January 14, 2026

**RE: North Domingo Baca Arroyo LOMR  
NFIP Case No. 25-06-2476P**

Thank you for your review of the LOMR submittal for North Domingo Baca Arroyo. Submittal items have been revised according to comments received from NFIP on October 17, 2025.

NORTH DOMINGO BACA LOMR

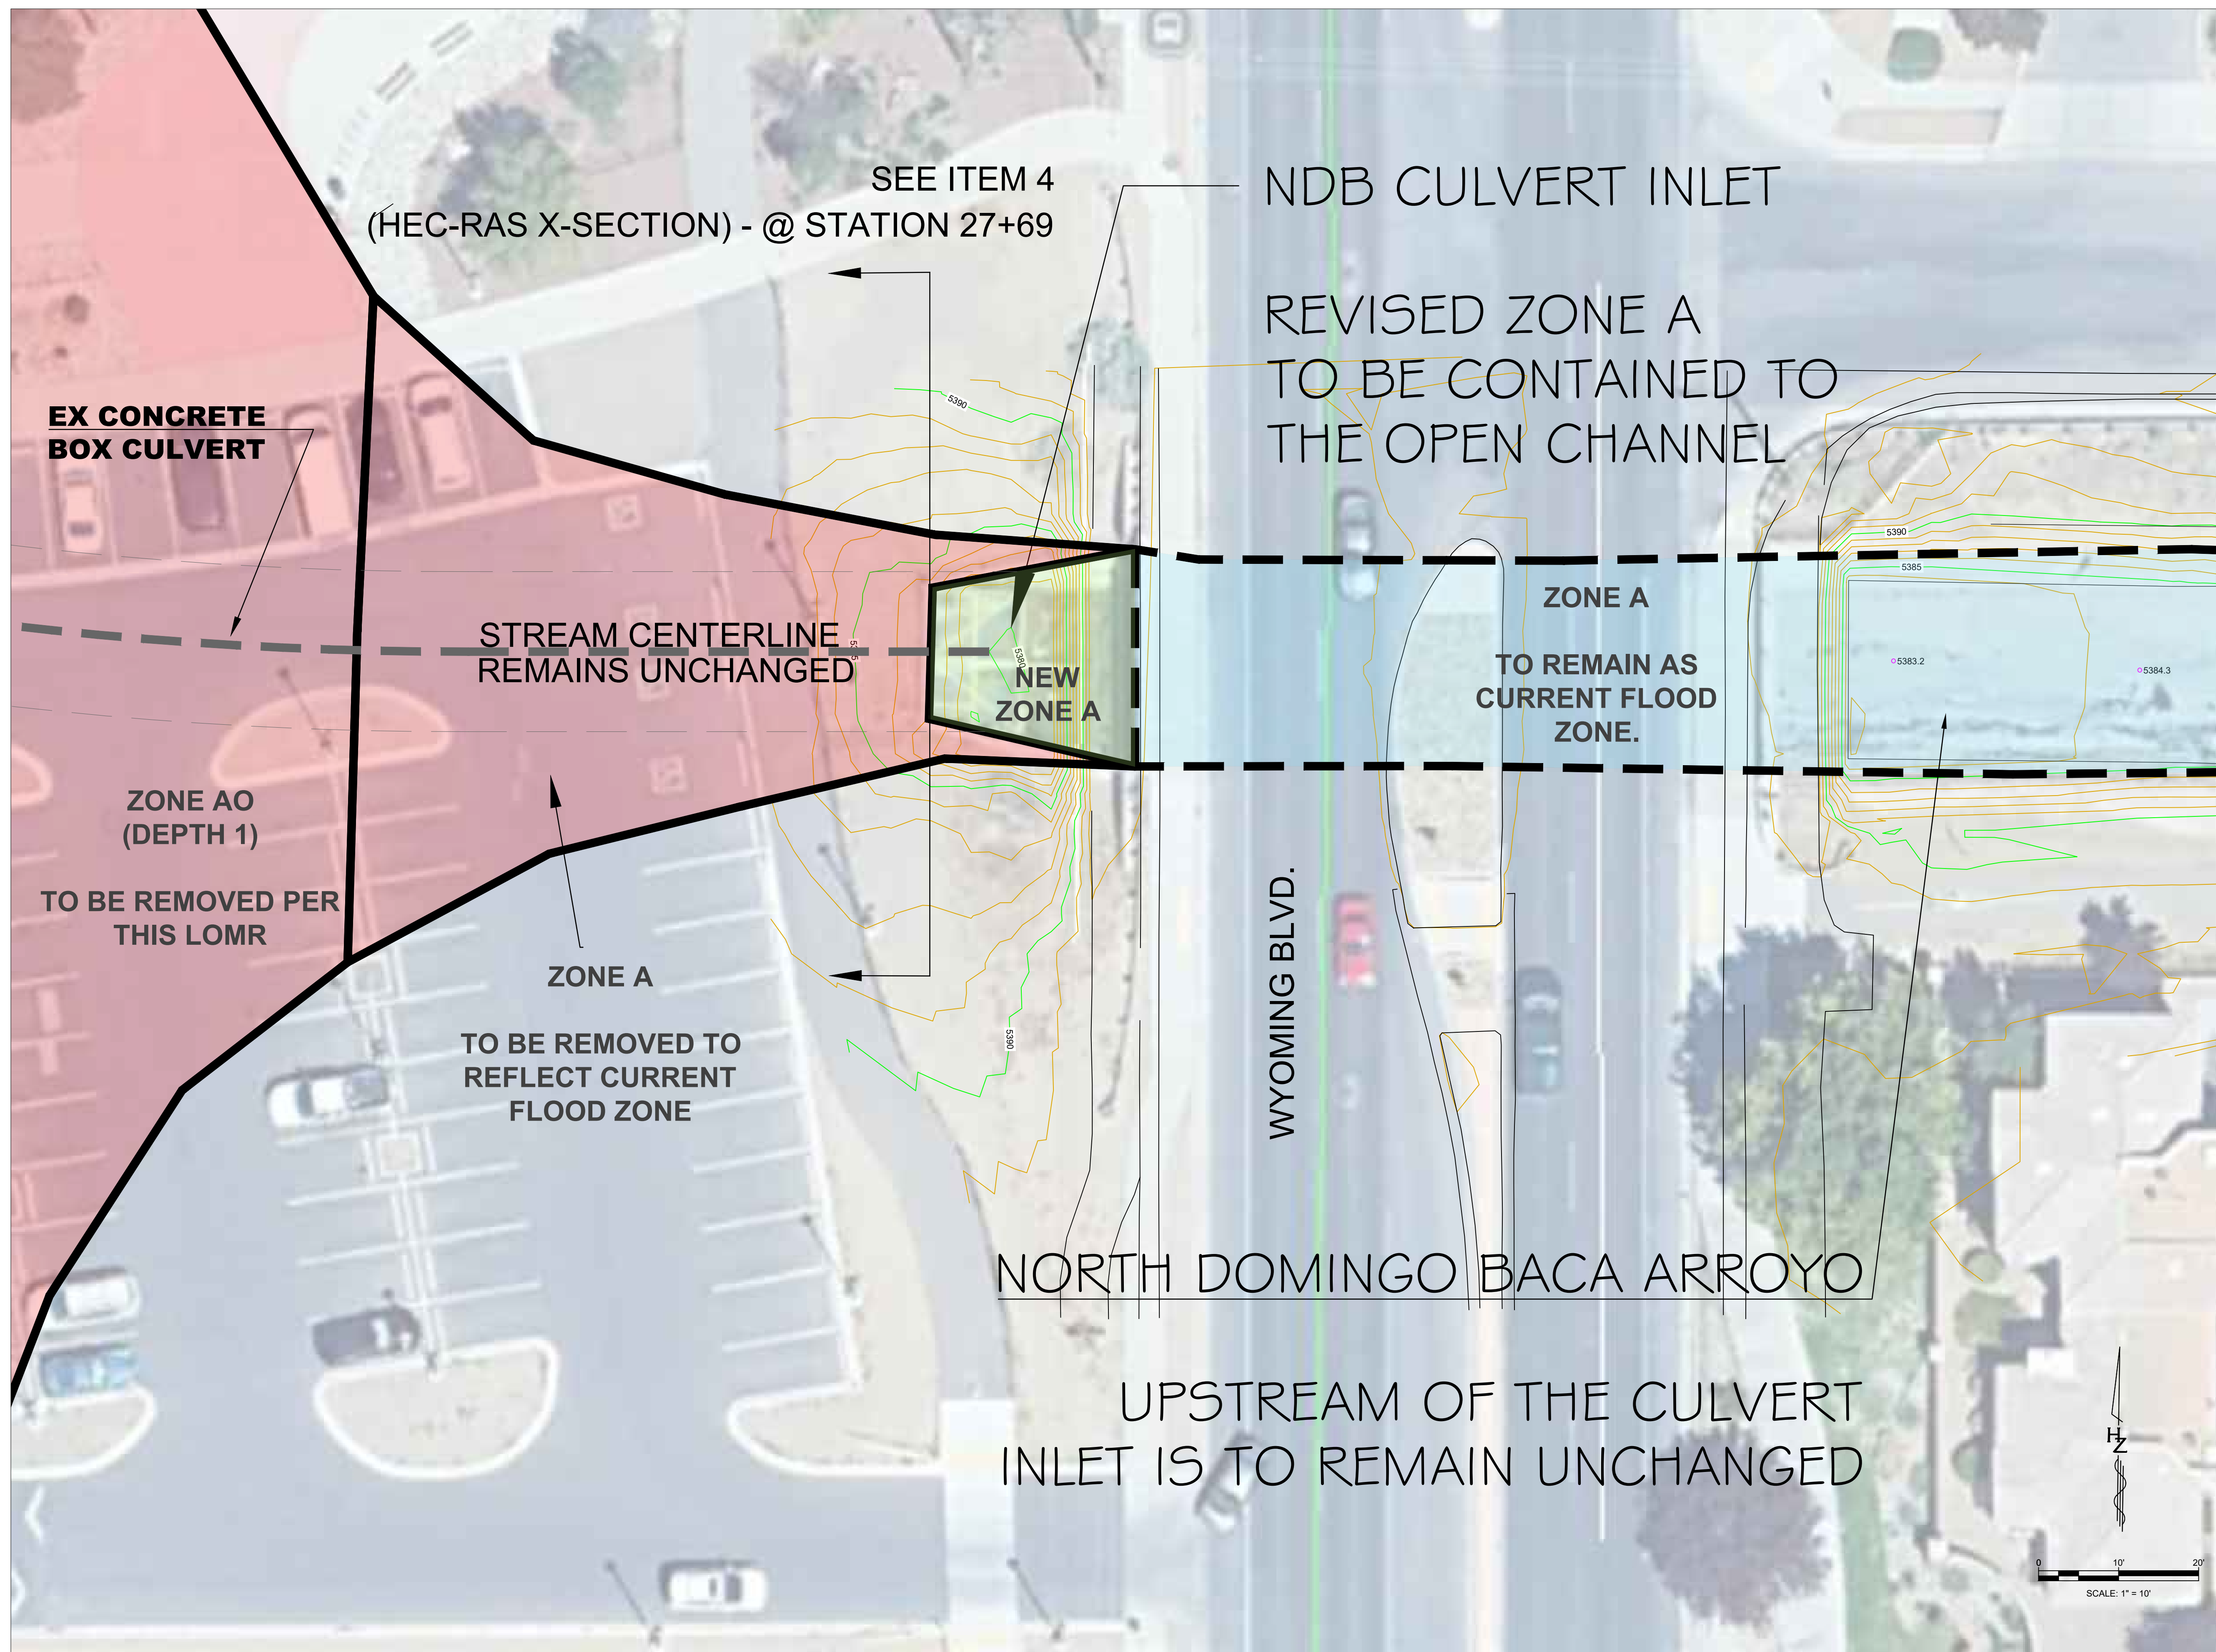
- a. *Please show the boundary delineations of the revised conditions 1-percent-annual-chance floodplain. The floodplain boundaries should generally follow the existing contours and should be delineated to the elevations calculated in the revised conditions hydraulic model. Please ensure the mapped floodplain top widths are consistent with the modeled output.*

- b. *Please show the boundaries of the currently effective conditions base floodplain as it is shown on FIRM panels 35001C0137H and 35001C0141G. For clarity, please show the effective and revised delineations in different line types and color.*

- c. *Please show smooth graphical tie-ins between the revised and effective flood hazard boundary delineations at the upstream and downstream ends of the revised reach. Please ensure that the revised delineations tie-in directly to the effective delineations and that the tie-ins occur a short distance upstream of the upstream most cross section in the revised conditions hydraulic model and a short distance downstream of the downstream most cross section.*

- d. *Please show and label the topographic contour information used for the boundary delineations of the base floodplain. For clarity, show the topographic contours as solid lines and show the major contours in a different color than the minor contours.*

- e. *Please show and label the locations and alignments of all cross-sections used in the hydraulic model that are within the revised area.*  
**The locations of cross-sections used in the hydraulic model within the revised area have been shown and labeled on the work map.**

- f. *Please show the stream centerline. If the revised stream centerline is different from the effective stream centerline, please ensure that the revised stream centerline ties-in to the effective centerline at the upstream and downstream*

**The locations of hydraulic structures included in the submitted hydraulic model are shown and labeled on the work map.**
- h. *Please show the north arrow, scale and scale bar.*

**A north arrow and scale are included on the work map.**
- i. *Please provide certification by a registered professional engineer.*  
**The topographic work map has been sealed and signed by a registered professional engineer.**

- j. *Please reference the vertical datum.*  
**The vertical datum of the survey is NAVD 88.**
3. *To assist our review and to expedite processing of this request, please provide CAD or GIS data that reflect the revised topographic work map. Please ensure the digital data are spatially referenced and cite what projection was used, so that the data may be used for accurate mapping. The data to show on the digital work map are the contour information, the stream centerline, the cross-section lines, the road crossings and hydraulic structures, the effective and revised flood hazard delineations, and the tie-in locations. Everything should be clearly labeled, and all information should be contained within the drawing and not externally referenced.*

**Zone AO will be completely removed due to the existing concrete box culvert. A portion of Zone A will be revised and the new boundary generally follows existing topography and the outline of the existing inlet structure near Wyoming Blvd.**

**The currently effective base floodplain boundaries from the two FIRM panels have been added to the work map. Effective and revised delineations are clearly differentiated using separate line types and colors for clarity.**

**Smooth graphical tie-ins between the revised and effective flood hazard boundaries are provided at both the upstream and downstream limits of the revised reach. The tie-ins connect directly to the effective delineations.**

**The topographic contours used to delineate the base floodplain are shown and labeled on the work map. Contours are shown as solid lines, with major contours shown as a different color than the minor contours.**

**The stream centerline has not been changed and remains as shown on the effective FIRM panels.**
- g. *Please show and label the locations of all structures included in the submitted hydraulic model that are within the revised area.*

**The topographic work map has been included as a CAD file. The vertical datum of the survey is NAVD 88. The spatial projection is New Mexico State Plane. The topographic work map includes contours, the stream centerline, cross-section lines, hydraulic structures, and the effective and revised flood hazard delineations.**
